Briefing Note

Our ref 64194/06/MS/OW
Date 4 June 2025
To Planning Inspectorate
From Oxford Aviation Services Limited

Subject **Deadline D1 – Further Written Statement**

- 1.1 This Statement has been prepared on behalf of Oxford Aviation Services Limited (“OASL”), the operators of London Oxford Airport (“the Airport”), in response to the Rule 8 letter received concerning the application by Photovolt Development Partners (“PVDP”) for an Order Granting Development Consent for the Botley West Solar Farm project.

\* Proposed Landscape areas are indicative  
 \*\* Areas of grassland beneath / not beneath solar arrays are managed through conservation grazing, and to deliver BNG

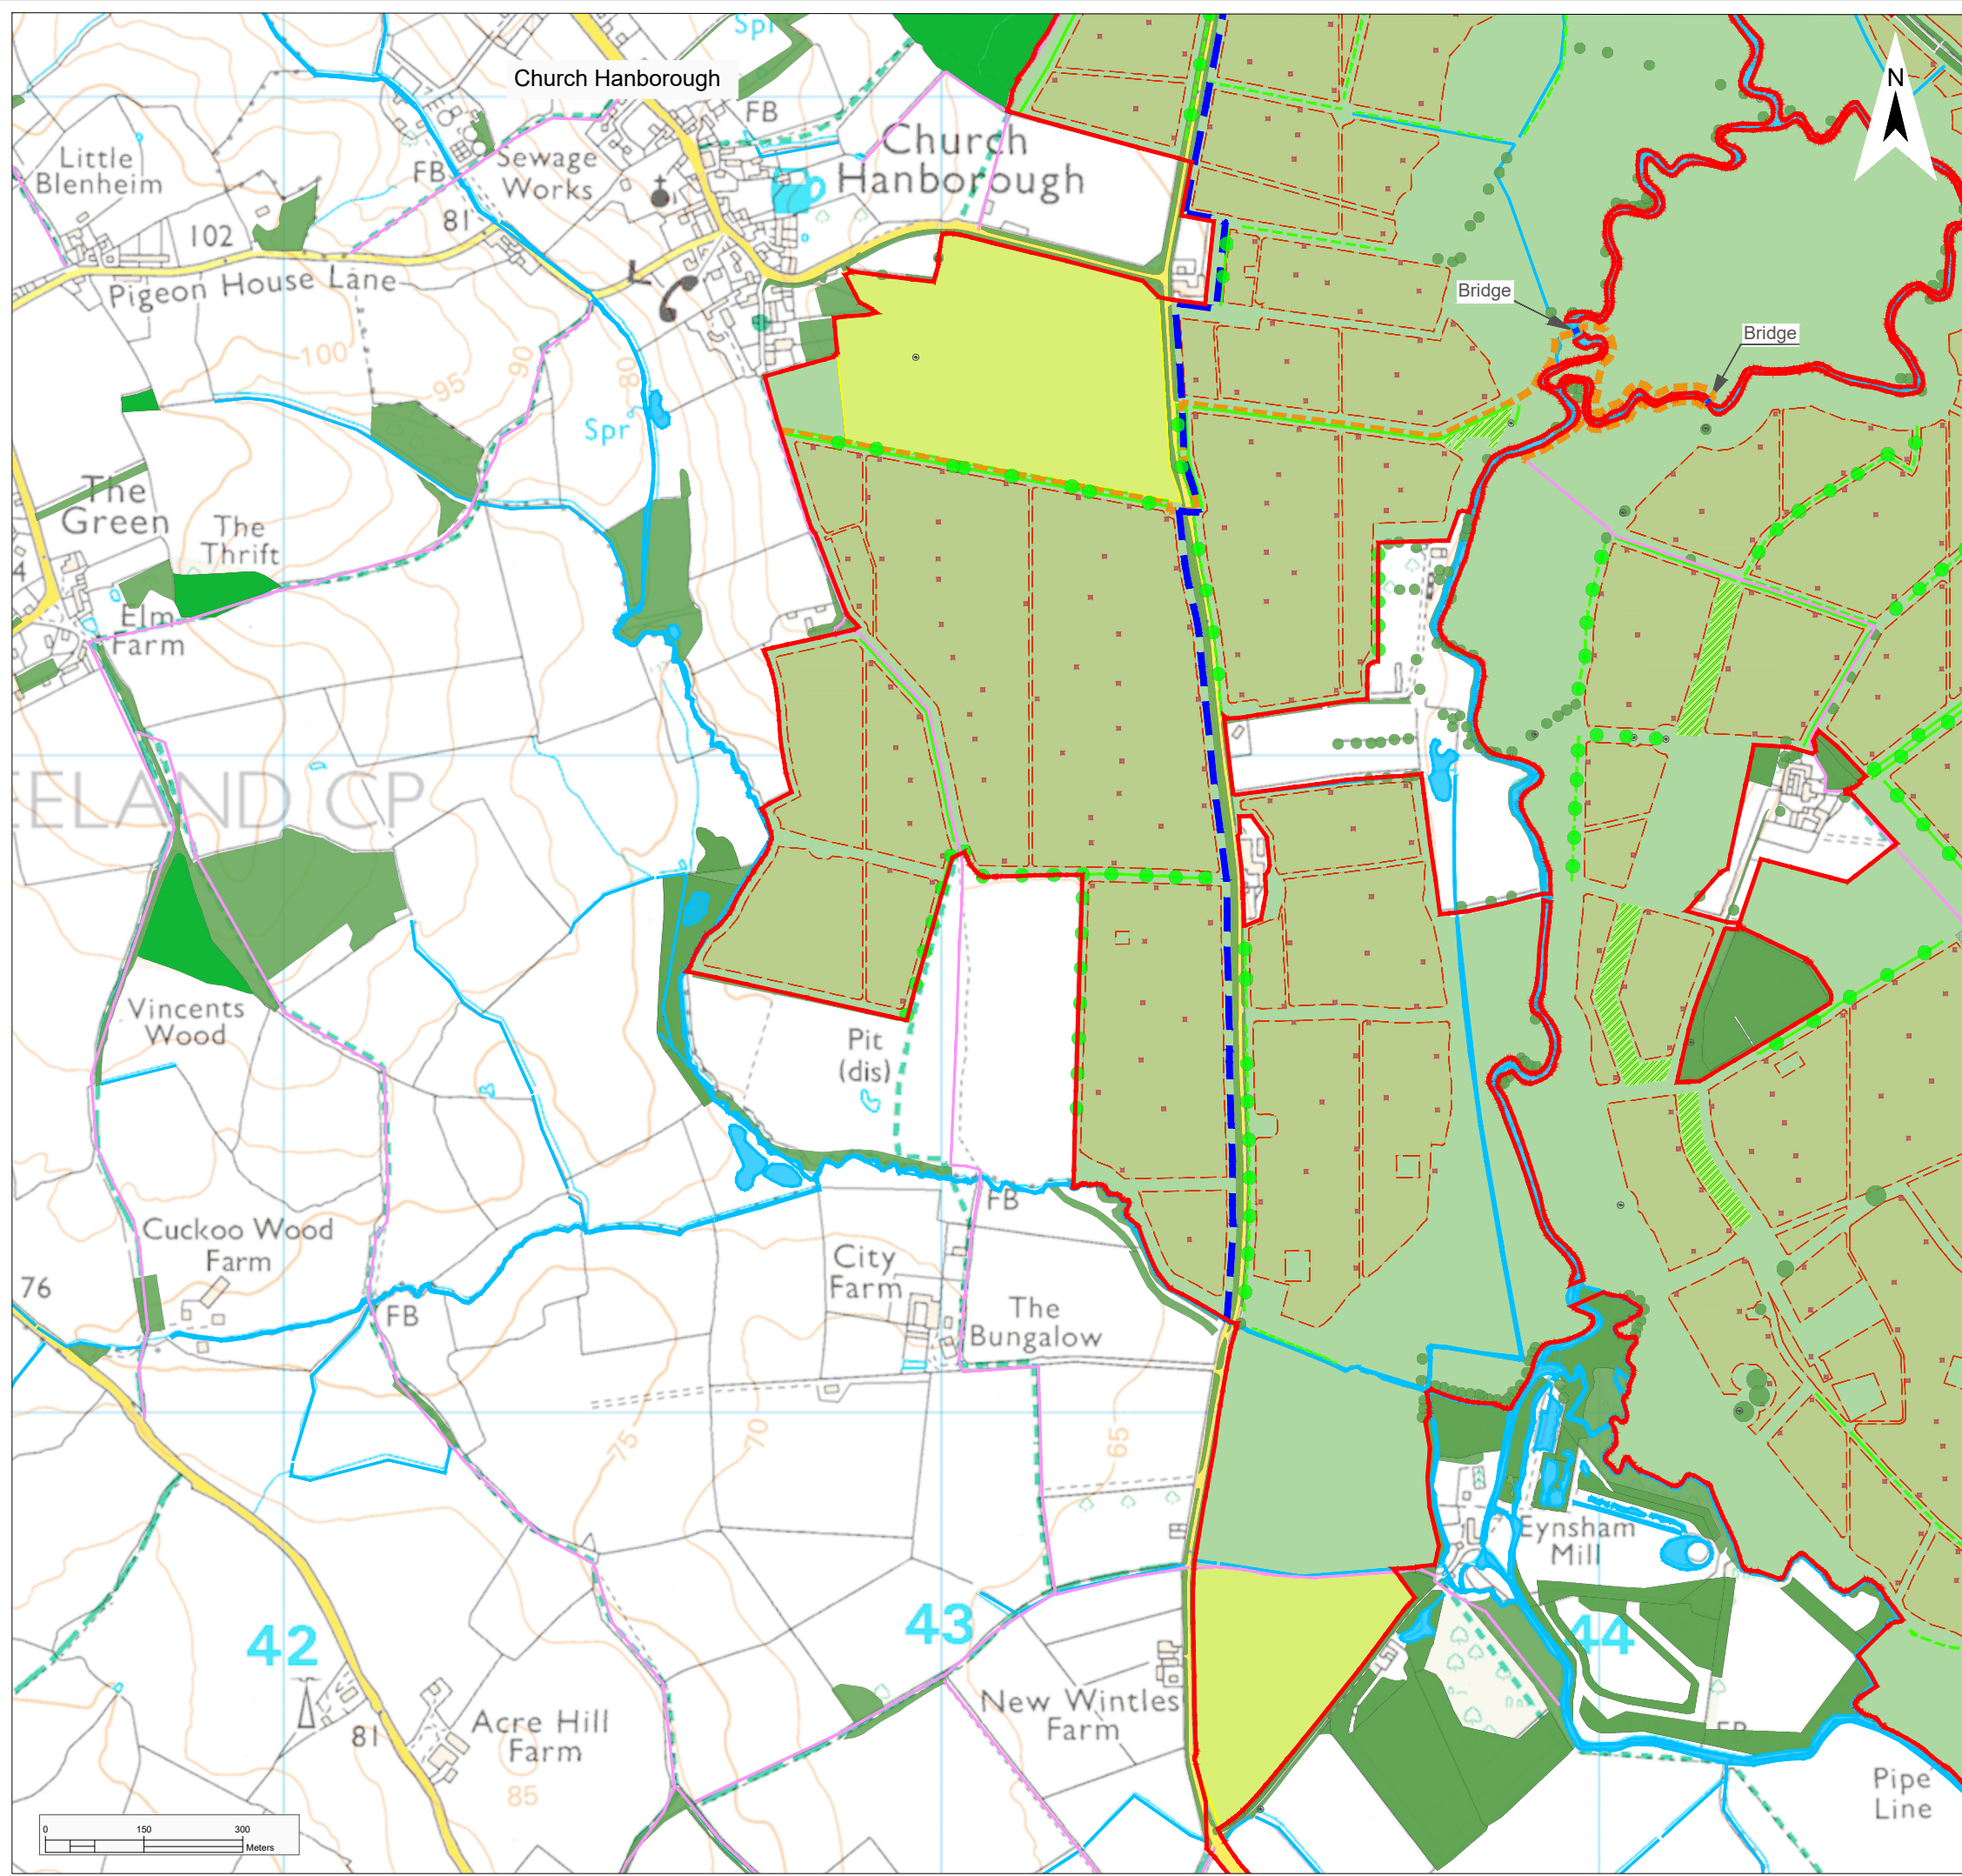
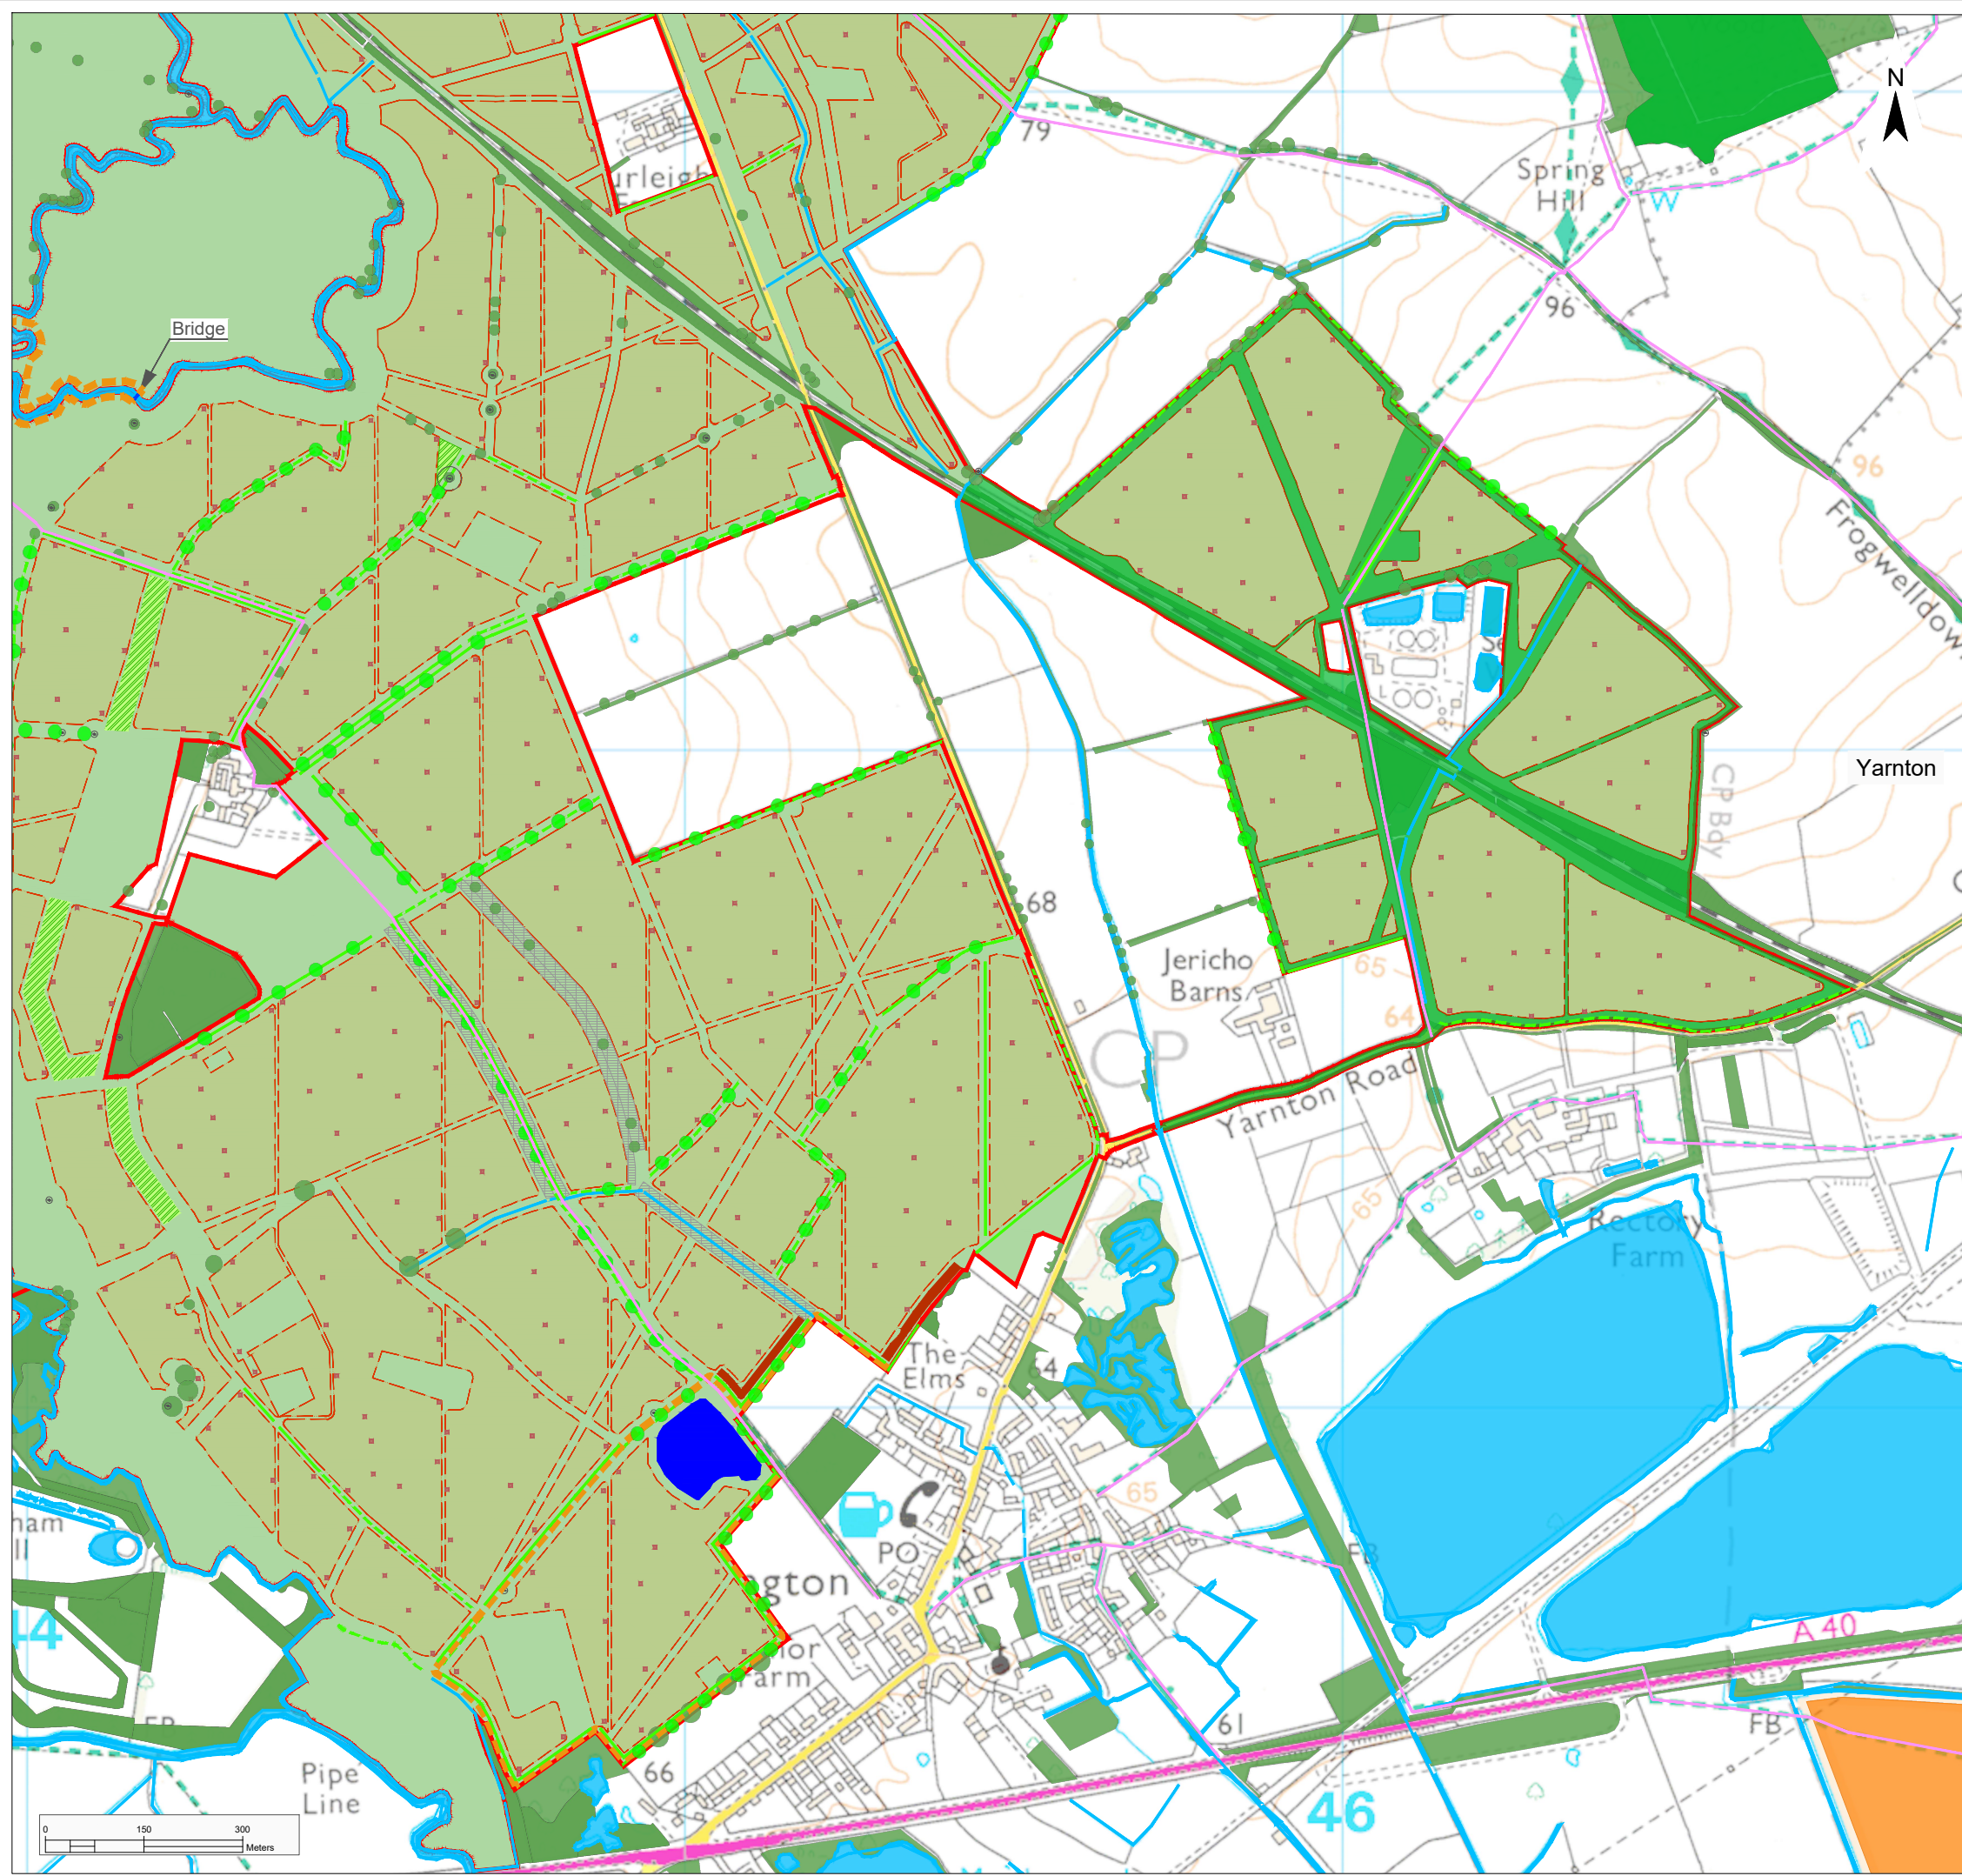
- 2.9 PVDP acknowledged that the submission documents had not considered the impact(s) of changing ecological activity around the Airport as a result of the development. It has agreed to review the proposals with a view to reducing zones of Green Infrastructure in areas around the Airport that might attract birds. They also agreed to consider other mitigations that could be introduced to assist the Airport in managing any increase in animal activity at the Airport as a result of the development.
- 2.10 PVDP agreed to present revised proposals to the Airport for review and agreement prior to submitting a proposed Change Order to the Inspectors.
